**SSD 6010 - One Residential Building (Student Accommodation) within
Darling Drive Plot**

Submission by:

26 July 2013

SHADOW DIAGRAMS: PLAN SHOWING THE HAYMARKET, WINTER SOLSTICE

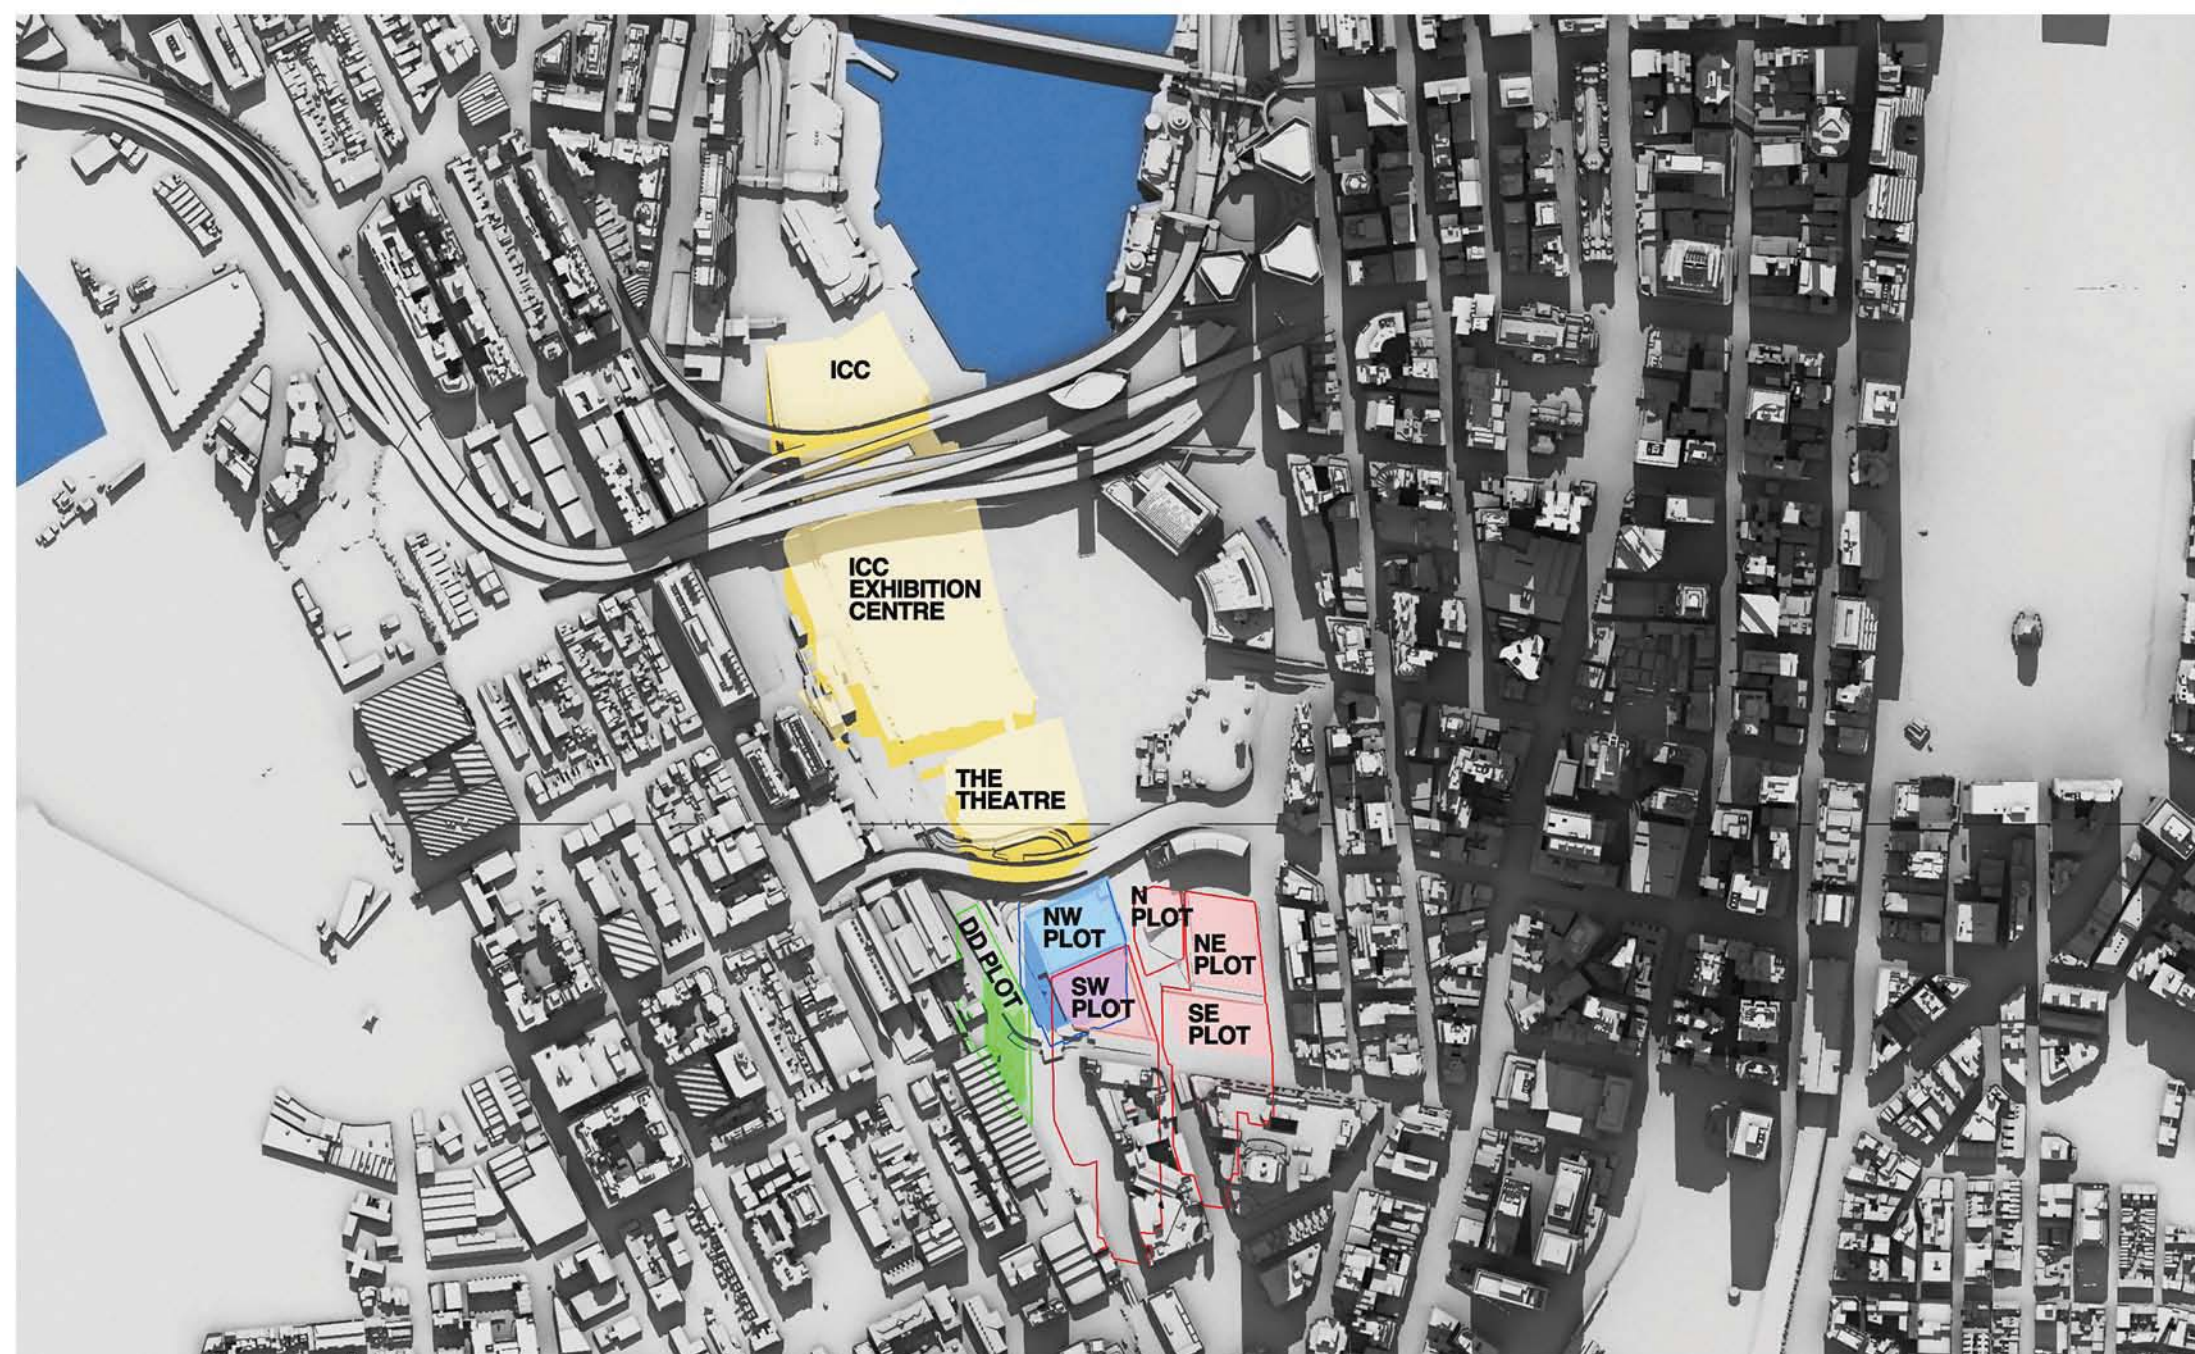
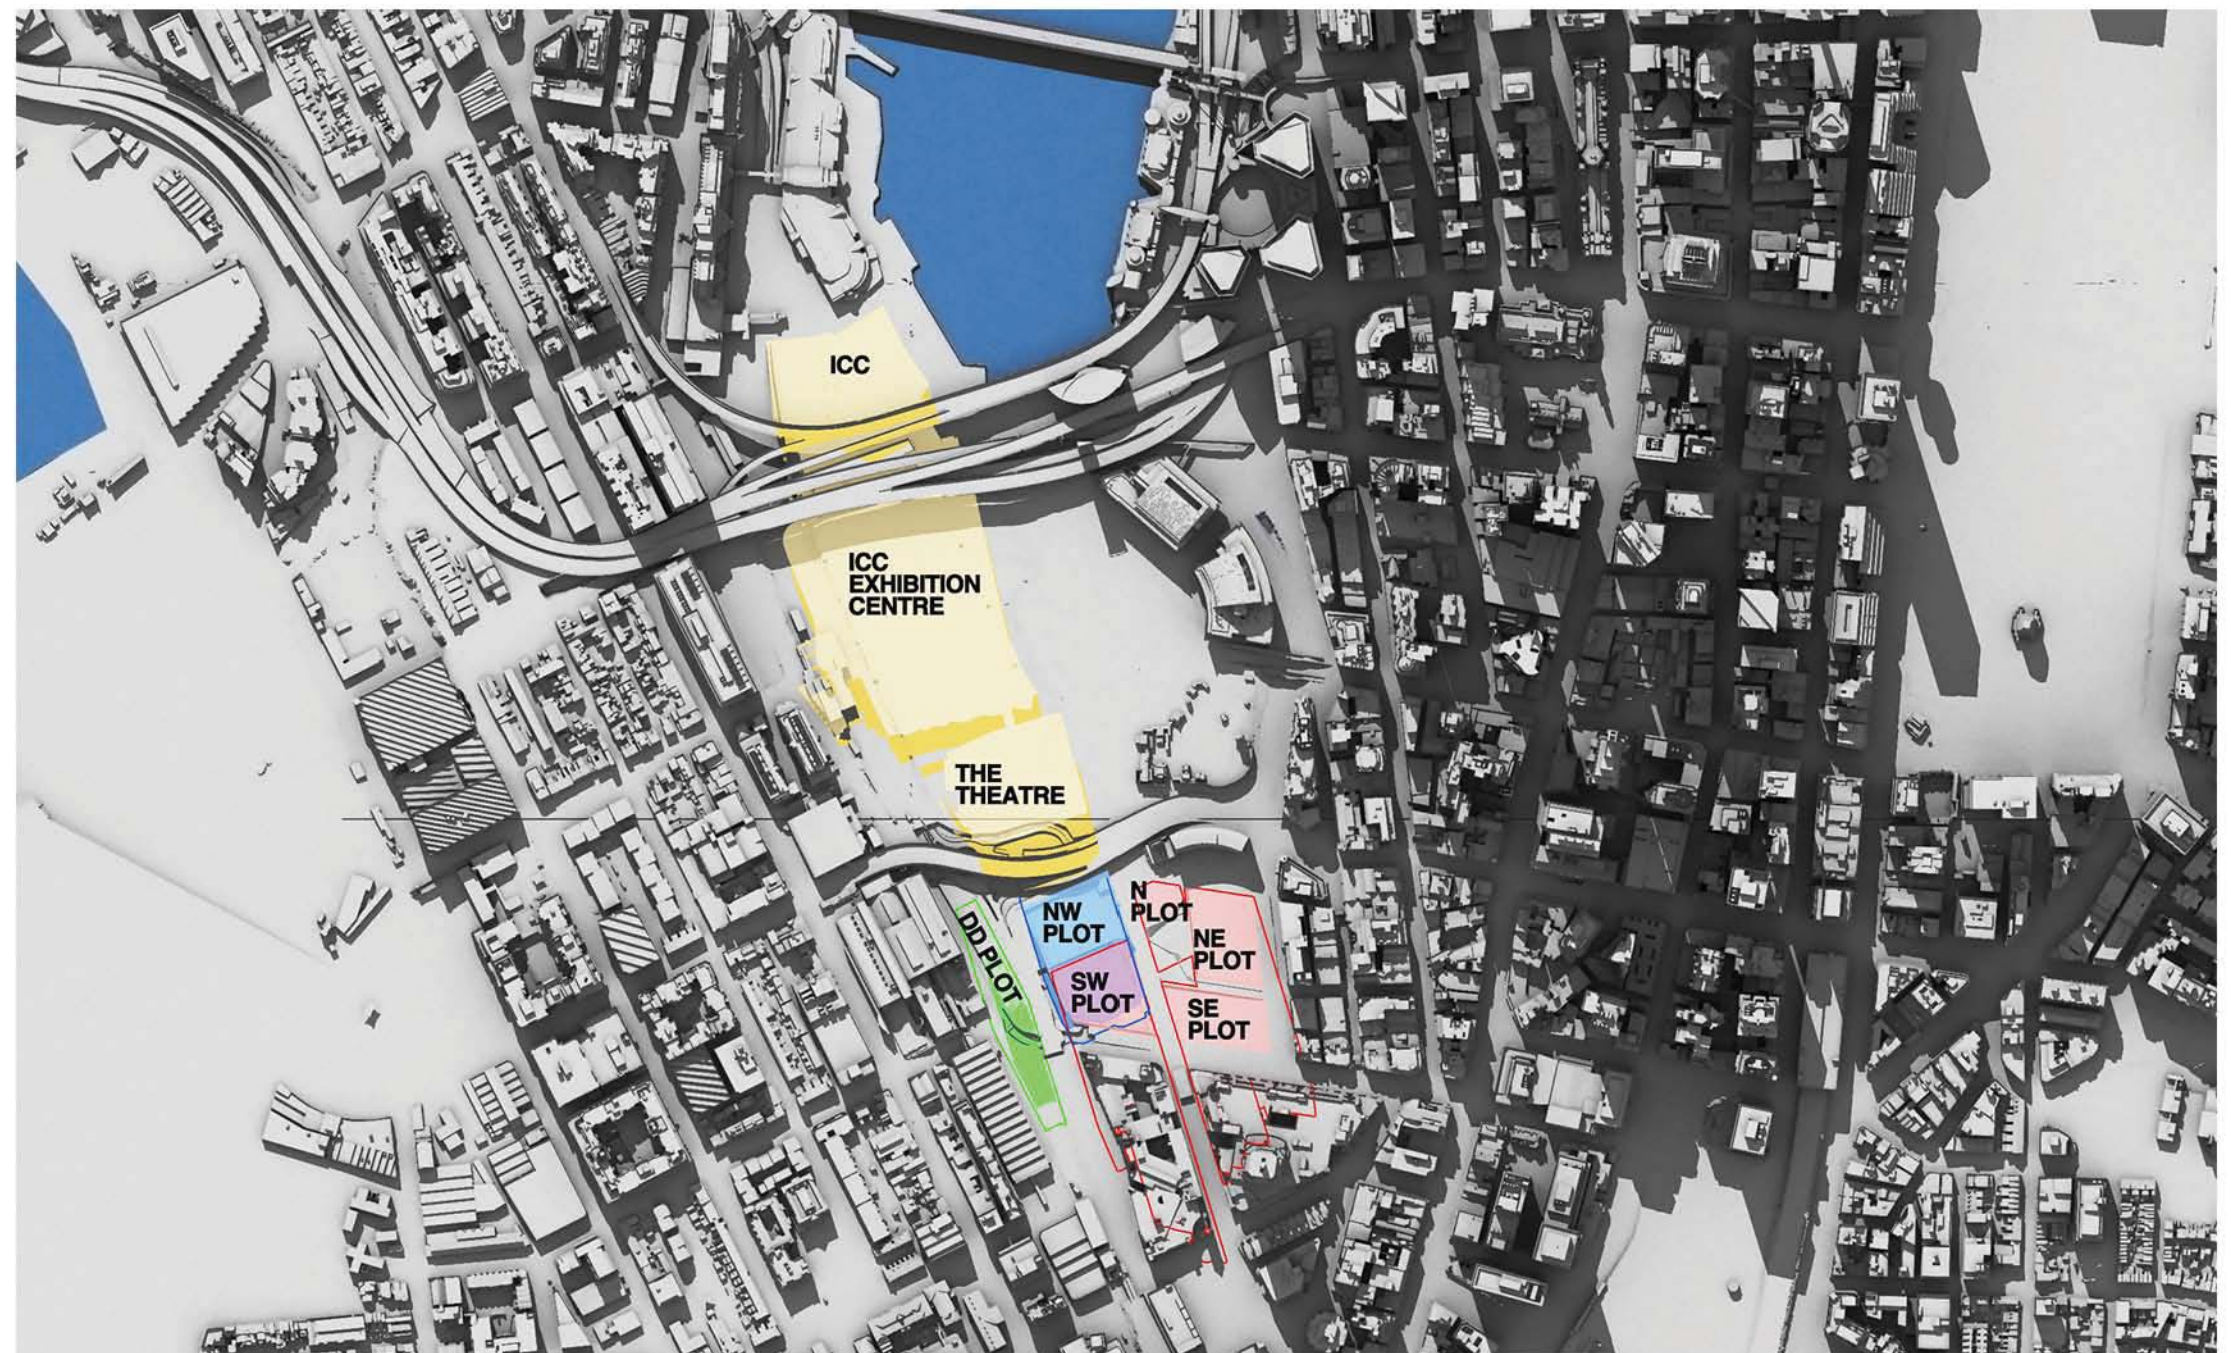
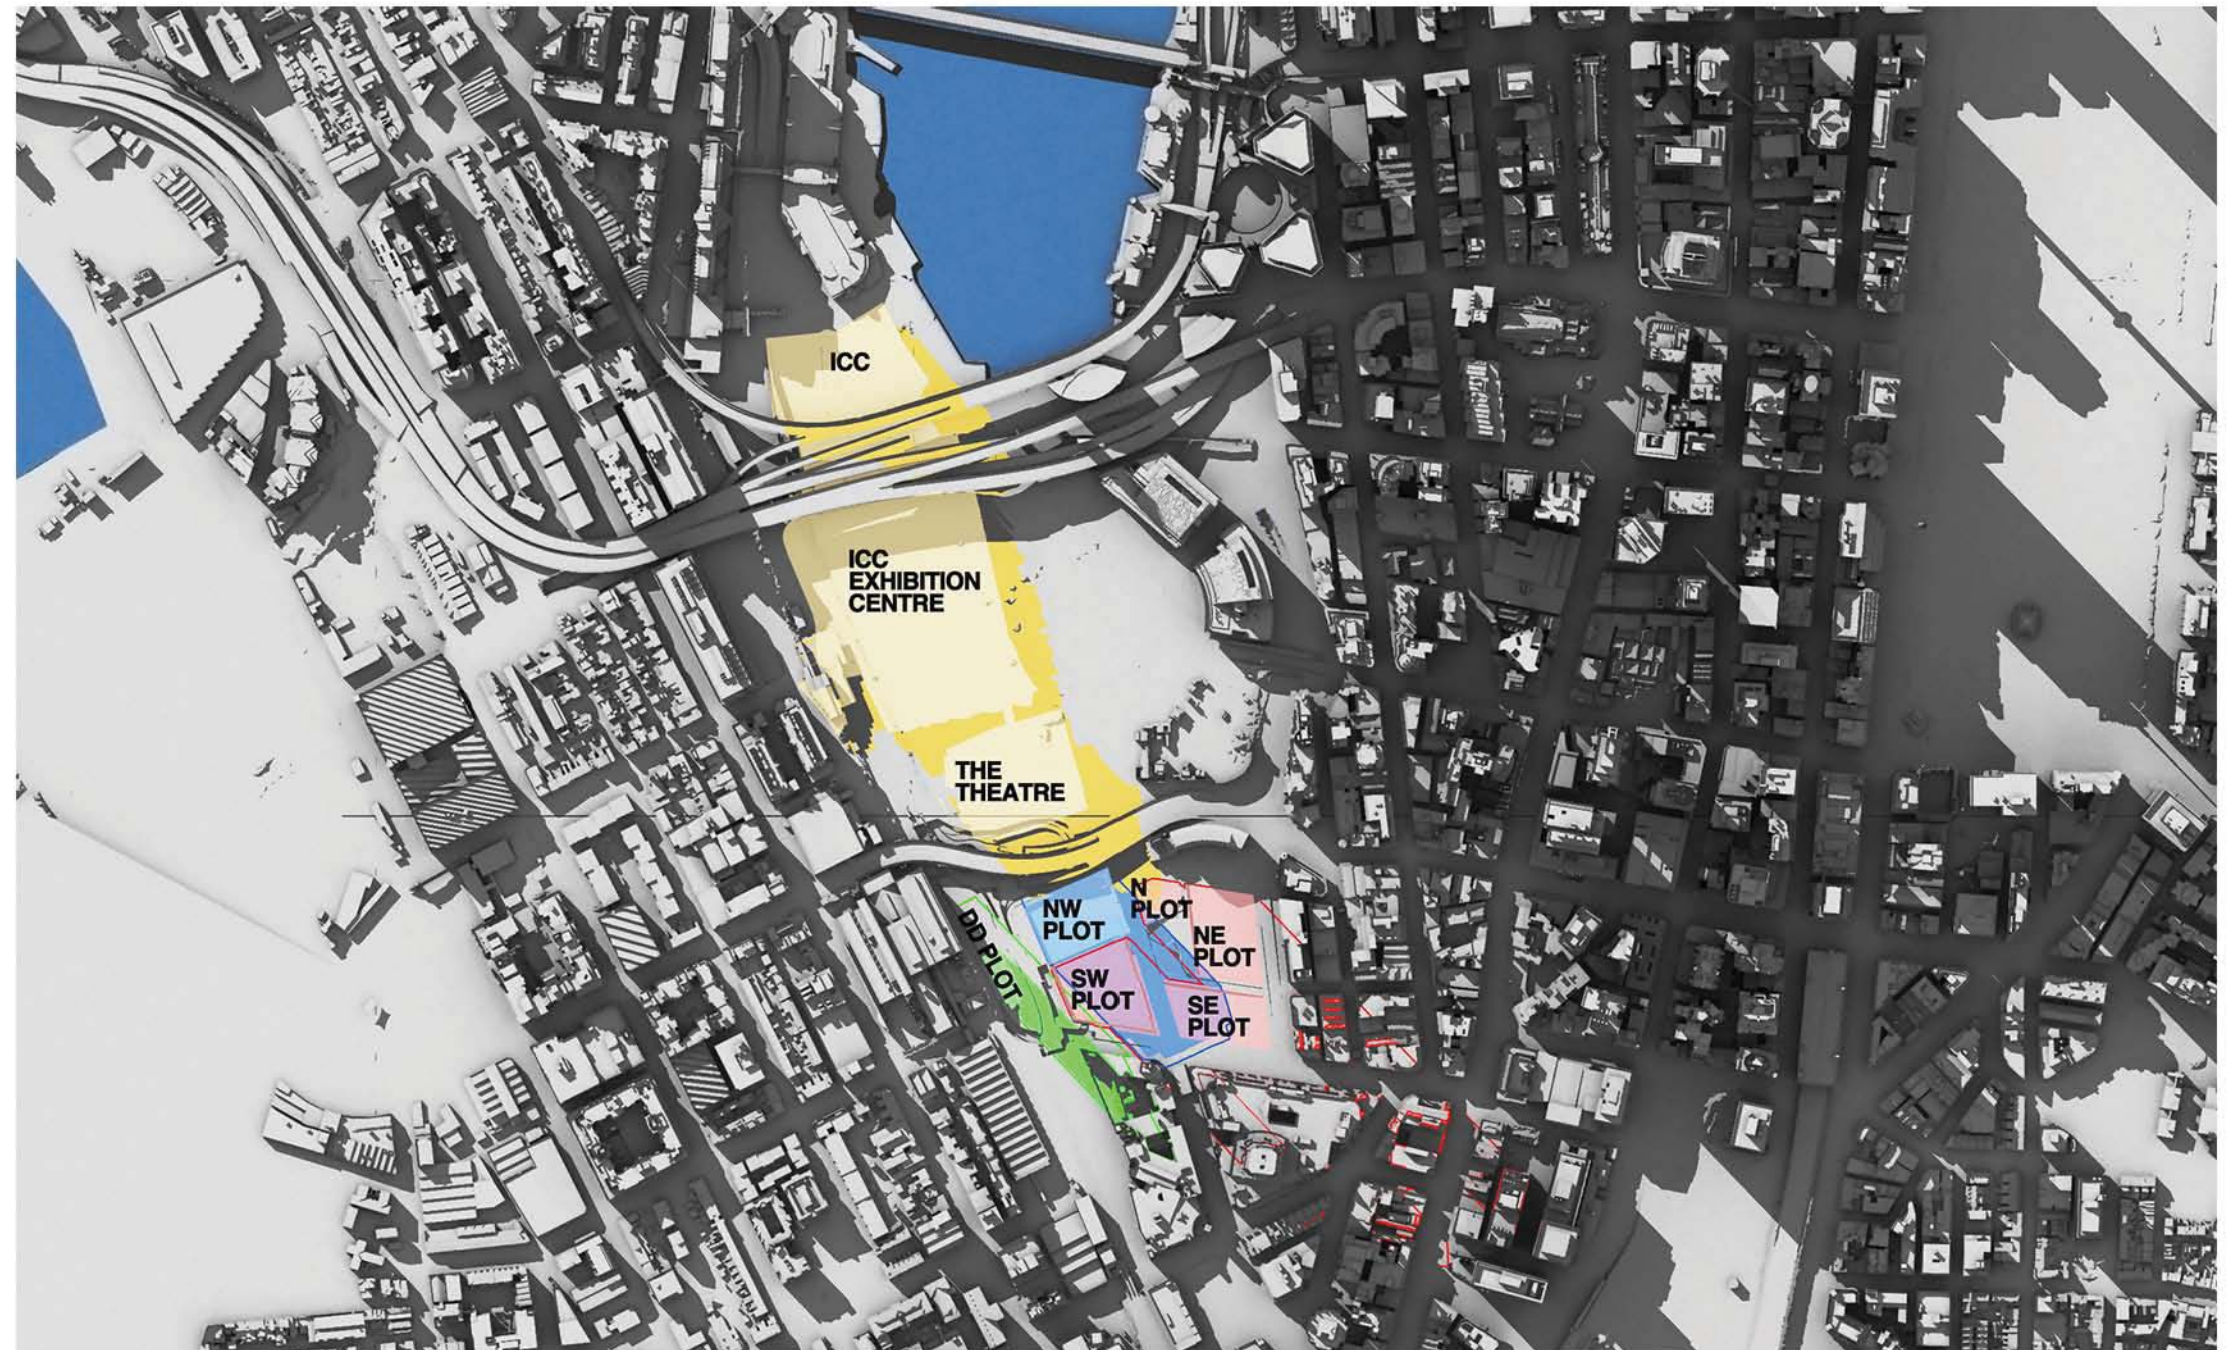
Proponent statement	Location of statement	Actual fact
<i>At mid-winter (22 June) there is some additional overshadowing impact to the Markey City podium and to the western elevation of The Peak Apartments after 2 pm. There is no additional overshadowing during the morning period, or the early afternoon.</i>	SSD5878 Response to Submissions and Amendments to Proposed Development Report, July 2013, Section 2.8 Overshadowing	That statement is misleading; in fact the podium additional overshadowing starts at 9 am and increases throughout the morning and early afternoon.
<i>At mid-winter (22 June) By 4pm, approximately 45-50% of the western elevation is in shadow, however the shadow has substantially moved off the northern façade such that only approximately 15-20% of the façade remains in shadow.</i>	SSD5878 Response to Submissions and Amendments to Proposed Development Report, July 2013, Section 2.8 Overshadowing	That statement is false, as can be seen from the diagram. The proponent has confused the western and northern facades.

Proponent statement	Location of statement	Actual fact
Winter solstice - 22 June <i>9:00 - 1.00 NO IMPACT</i>	SSD5878 Appendix H. Supplementary Design Report, Section 6. Amendments Winter solstice - 22 June	That statement is false; in fact the podium roof additional overshadowing starts at 9 am and increases throughout the 9 am to 1 pm period (and continues to increase thereafter)
Winter solstice - 22 June <i>2:00 – The western edge of the Market City podium roof is overshadowed</i>	SSD5878 Appendix H. Supplementary Design Report, Section 6. Amendments Winter solstice - 22 June	Most of the western and northern podium roof is overshadowed.
Winter solstice - 22 June <i>3:00 – The Market City podium roof is overshadowed from the north west corner to the Peak Tower;</i>	SSD5878 Appendix H. Supplementary Design Report, Section 6. Amendments Winter solstice - 22 June	Almost the entire podium roof is overshadowed.

Winter solstice - 22 June <i>4:00 – The Market City podium roof is overshadowed from the north west corner to the in front of the north elevation of the Peak Tower;</i>	SSD5878 Appendix H. Supplementary Design Report, Section 6. Amendments Winter solstice - 22 June	True, and this has substantially been the case since 2pm.
Winter solstice - 22 June <i>4:00 – 15-20% of the Peak Tower northern elevation remains in shadow since 3pm;</i>	SSD5878 Appendix H. Supplementary Design Report, Section 6. Amendments Winter solstice - 22 June	Actually 45-50% of the Peak Tower northern elevation remains in shadow since 3pm.
Winter solstice - 22 June <i>4:00 – A portion of the Peak Tower north elevation (15-20%) now receives direct sunlight when compared to the maximum building envelope model – portions of which were previously overshadowed at 3pm.</i>	SSD5878 Appendix H. Supplementary Design Report, Section 6. Amendments Winter solstice - 22 June	The reduction compared with the maximum building envelope model can be seen from the diagram to be only about 5-10%.
